ENG-SF22025-R4-GEC Plan.pdf Markup Summary

Subject: Text Box
Page Index: 2
Date: 6/4/2024 4:18:56 PM
Author: eschoenheit
Color: ■
Layer:
Space:
Page Label: [1] C1.1

JULY 1, 2022  
 C1.2 SHEET 2 OF 4

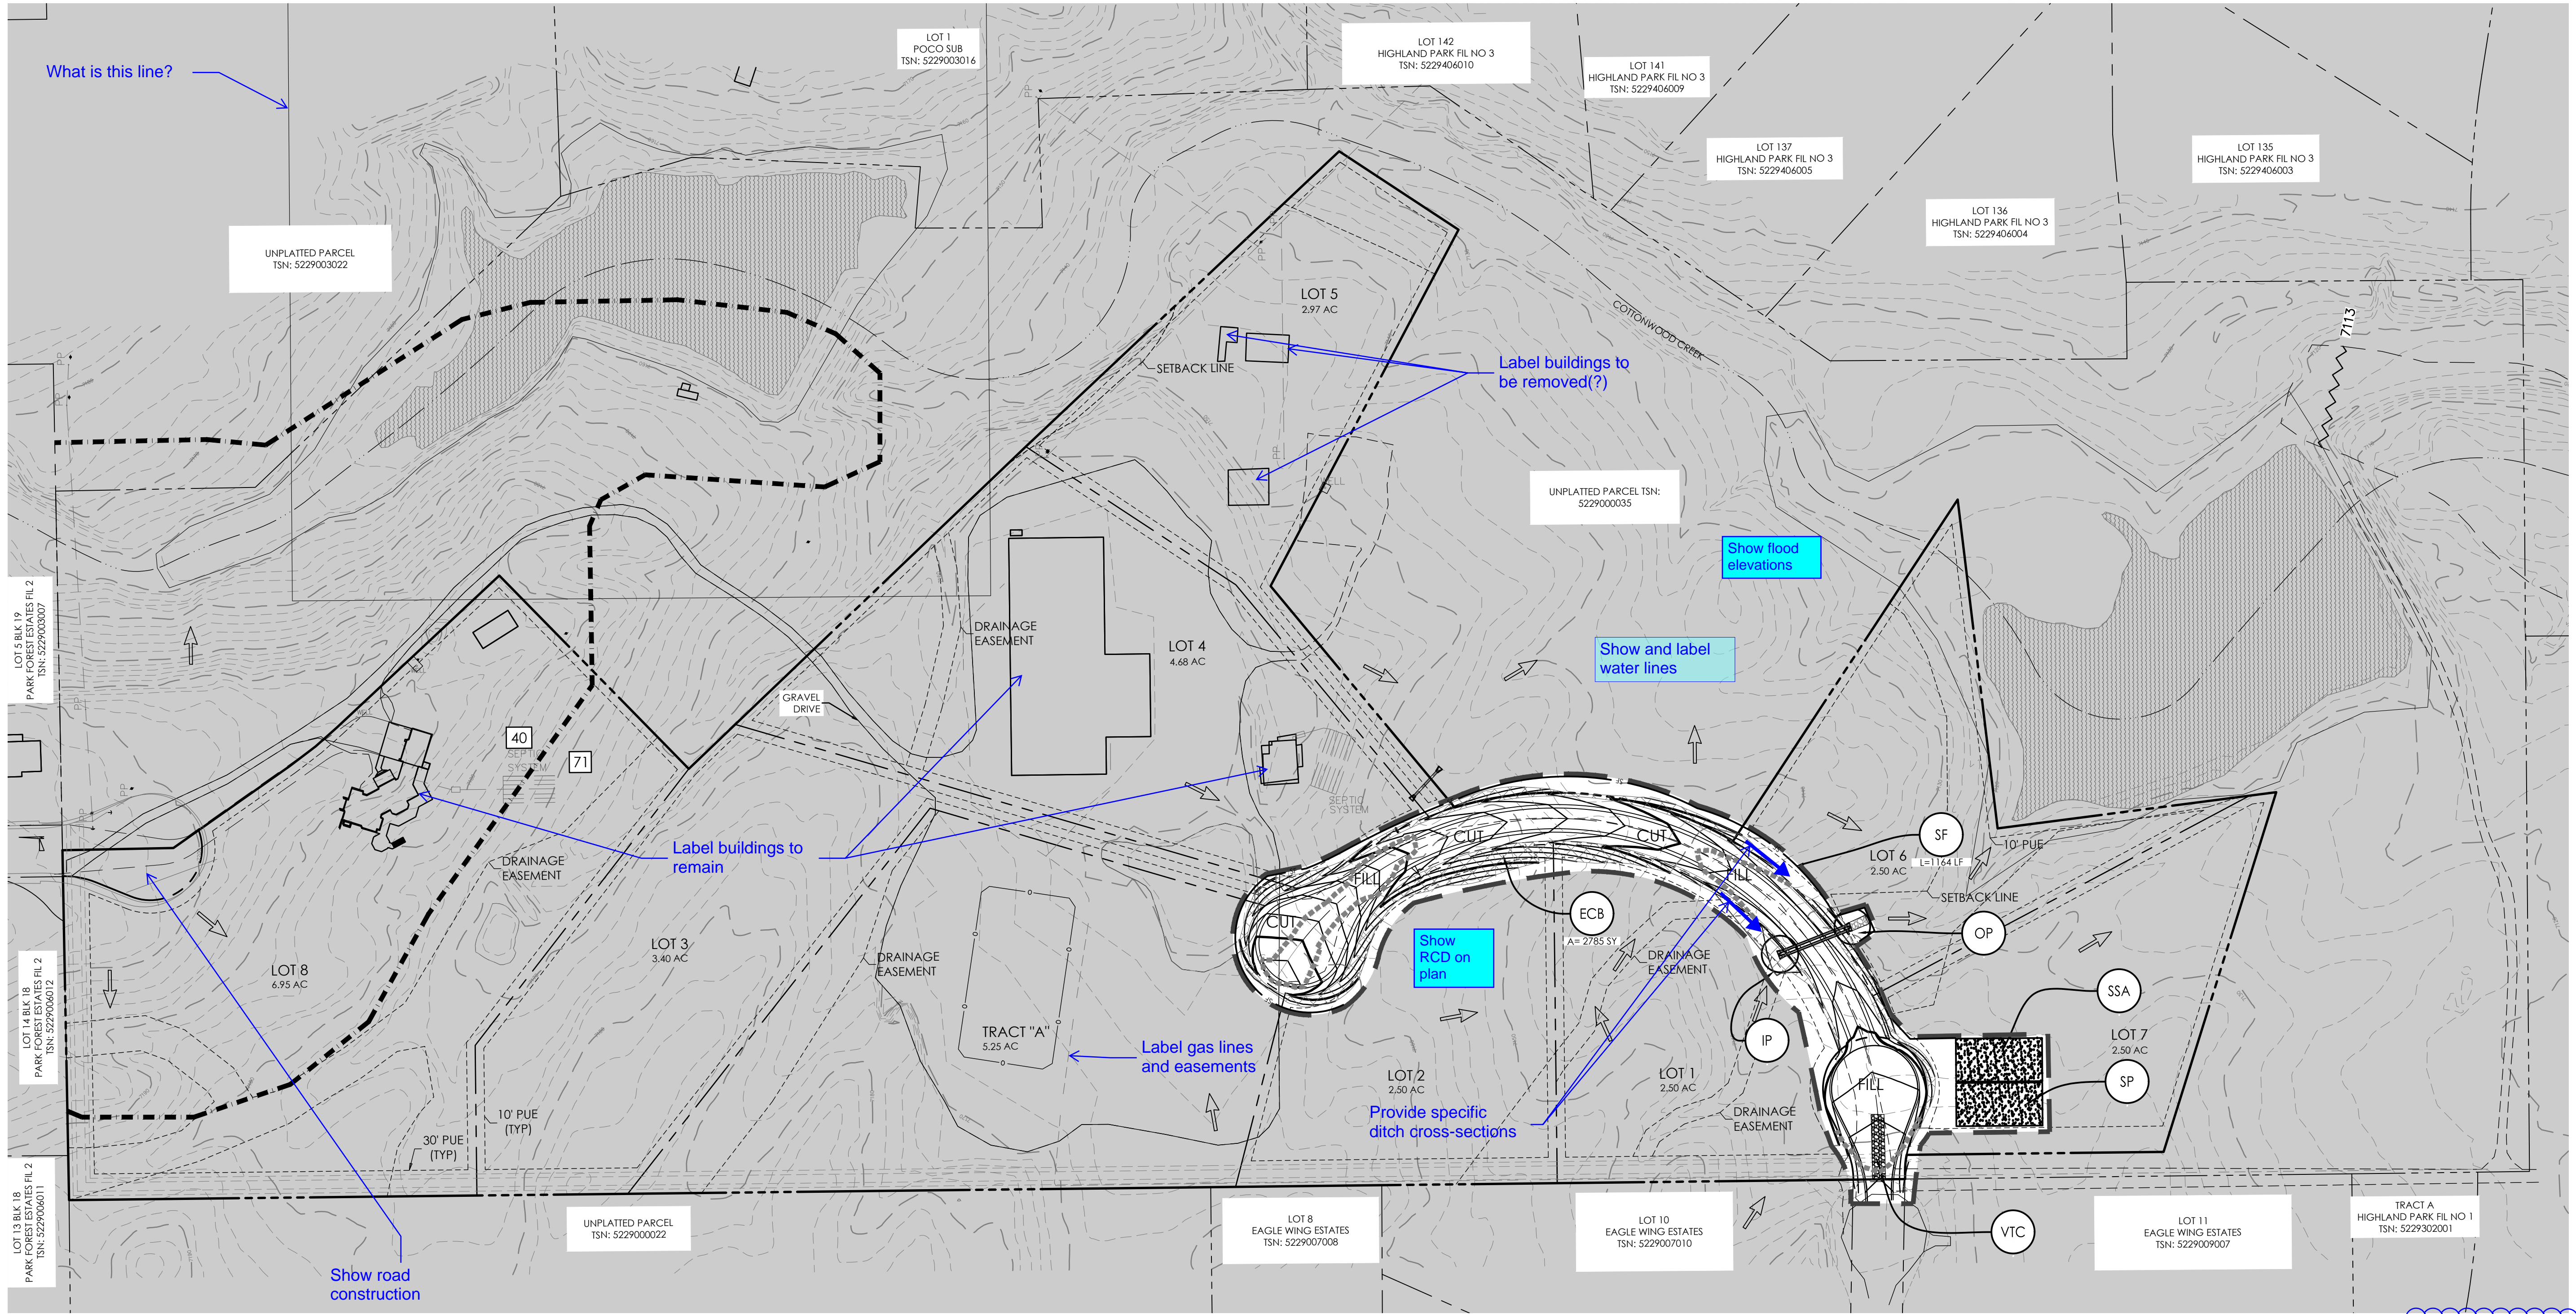
Please depict where the proposed culvert is for lots 3,4,5,6 as detailed in the FDR on page 12 for the FDR_v5

Verify whether this area needs to be seeded and mulched or gravel road

add note to state that no grading on 'others' property with out appropriate permissions.

If the driveways go through the lot flags the pond needs to be filled in. The developer can do this or the lots can require engineered site plans.
